CITY OF ALBUQUERQUE

July 31, 2013

Re: Red Rock Roasters, 4801 Jefferson St NE
Request for Permanent C.O. –Accepted
Engineer's Stamp dated: 11-14-12, (F17/D096)
Certification dated: 7-26-13

GRADING AND DRAINAGE PLAN

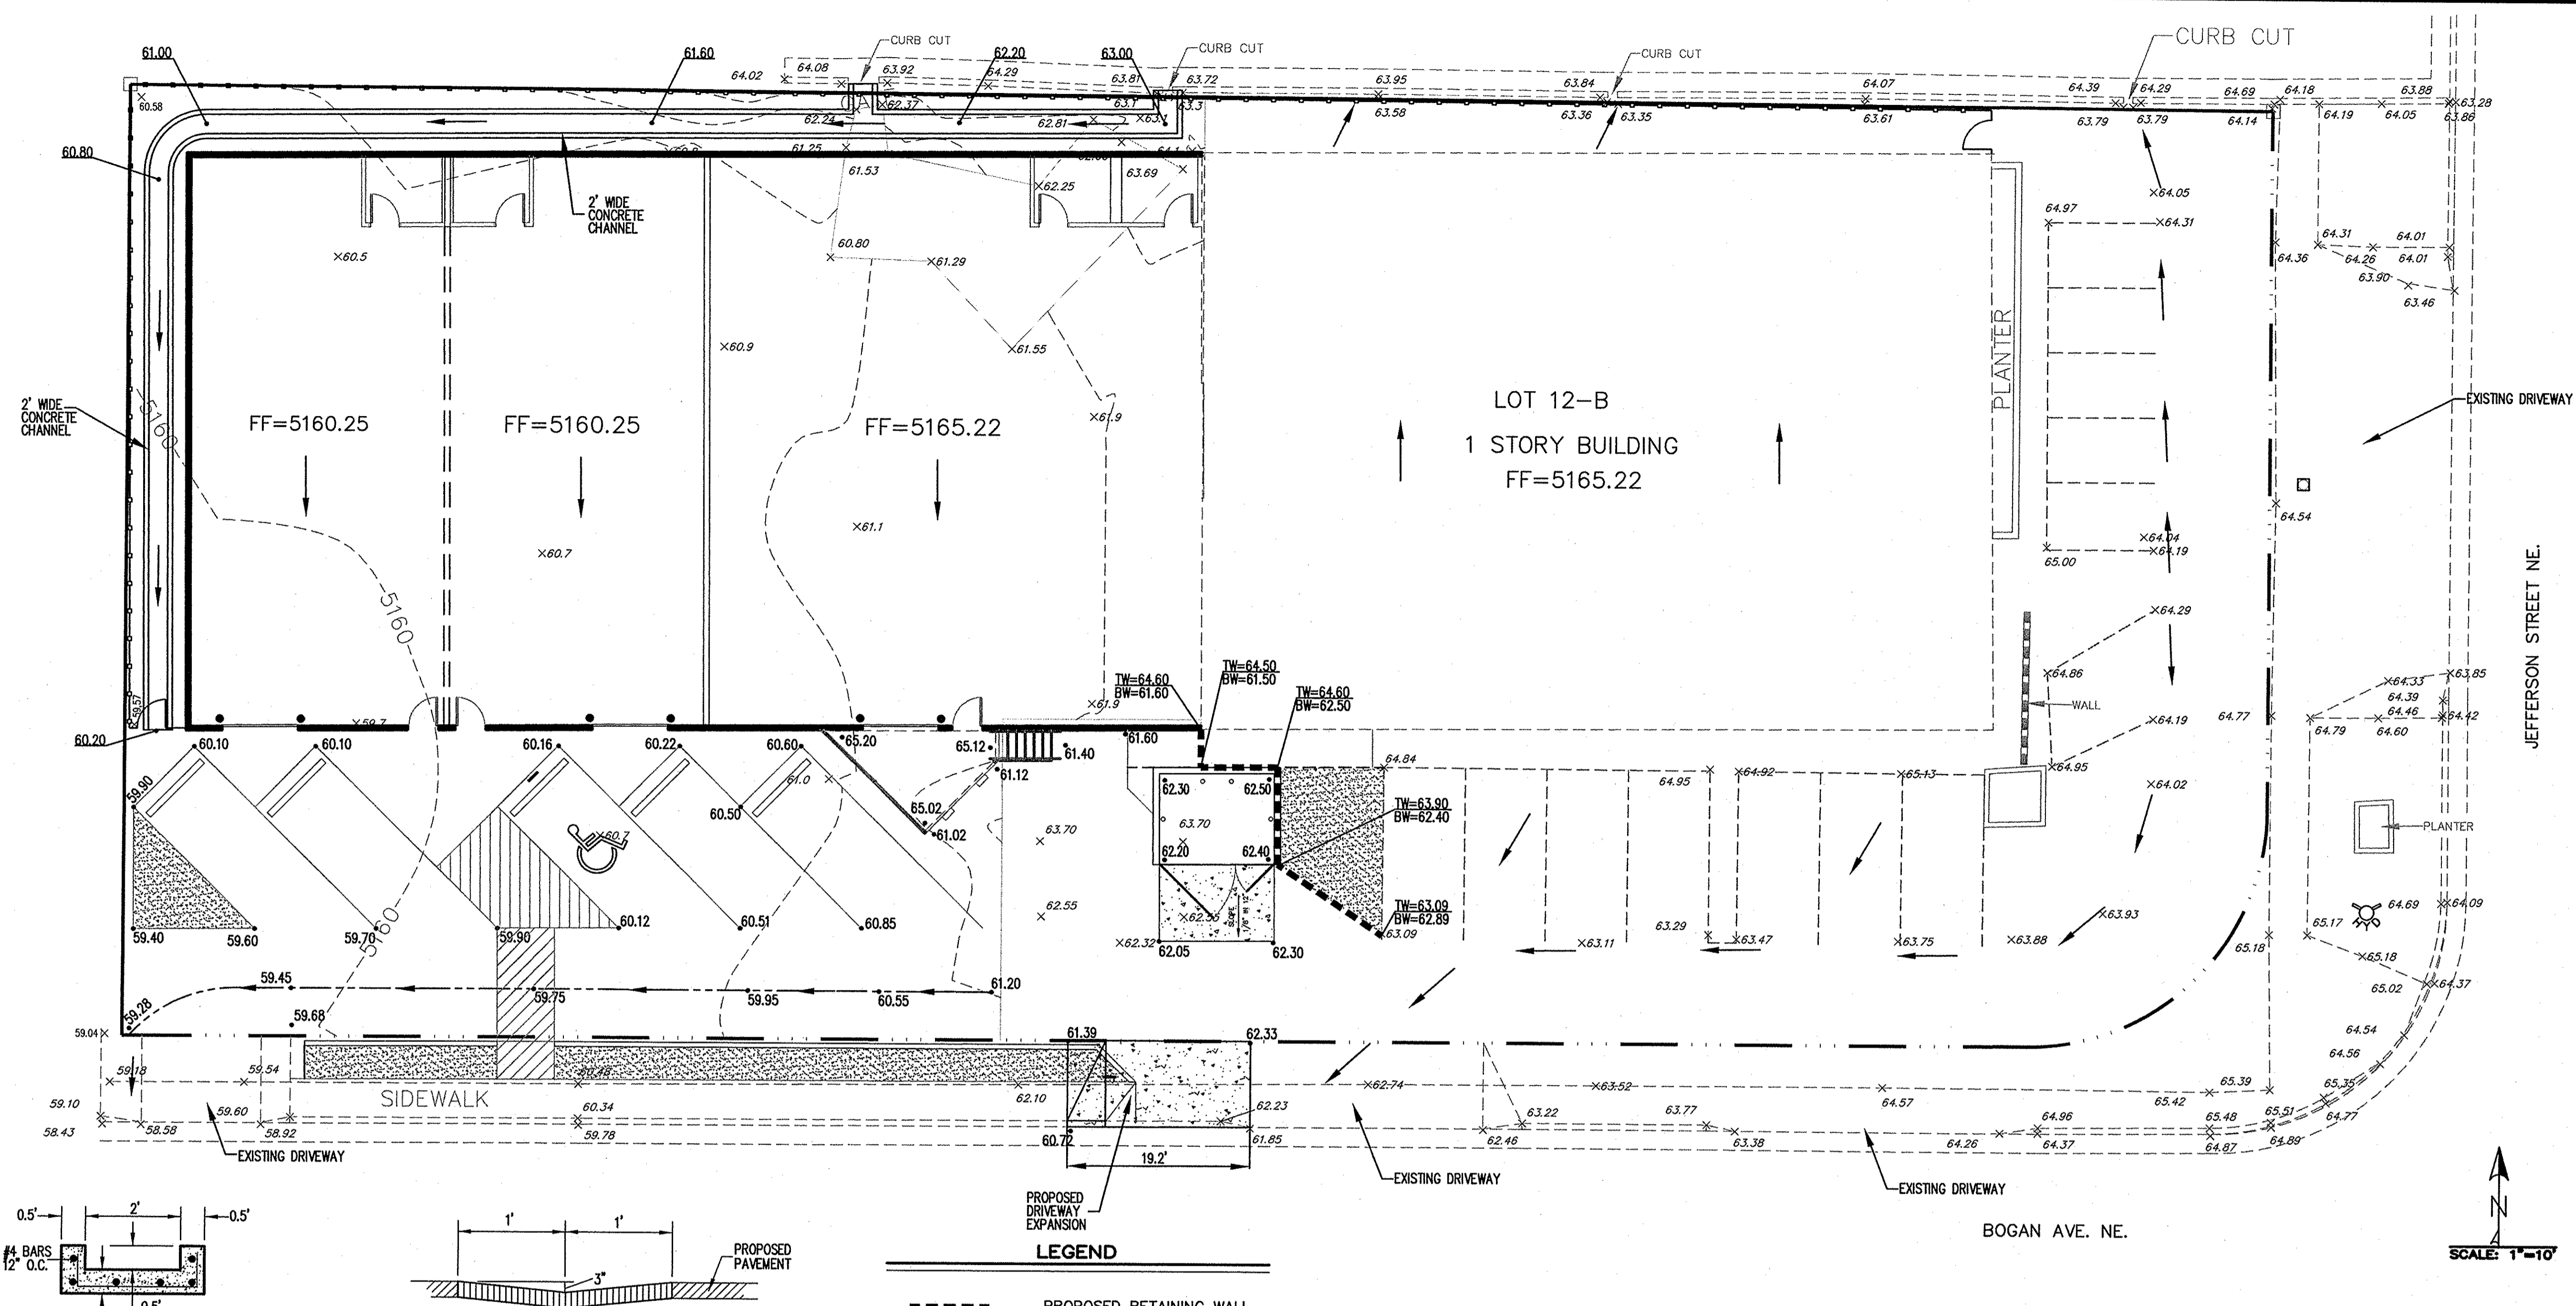
- Indicate the direction of roof flows on the plan.
- Provide details of the proposed swale indicated in the legend.
- Provide spot elevations along the west end of property.
- An agreement for the curb cuts and cross drainage is needed.
- Are the speckled areas landscaping?
- All landscaped areas need to be depressed?

I spoke with zoning about this plan because of the lack of landscaping. Judging from this plan it is believed that not enough landscaping has been provided. Contact David Kilpatrick at 924-3838 for a better idea of how much landscaping will be needed for this site. I believe that the G&D plan may change.

Based upon the information provided in your submittal received on 11-14-12, the grading and Drainage Plan is approved for Building Permit. Please attach a copy of this approved plan to the construction sets prior to sign-off by Hydrology. Prior to Certificate of Occupancy release, Engineer Certification per the DPM checklist will be required.
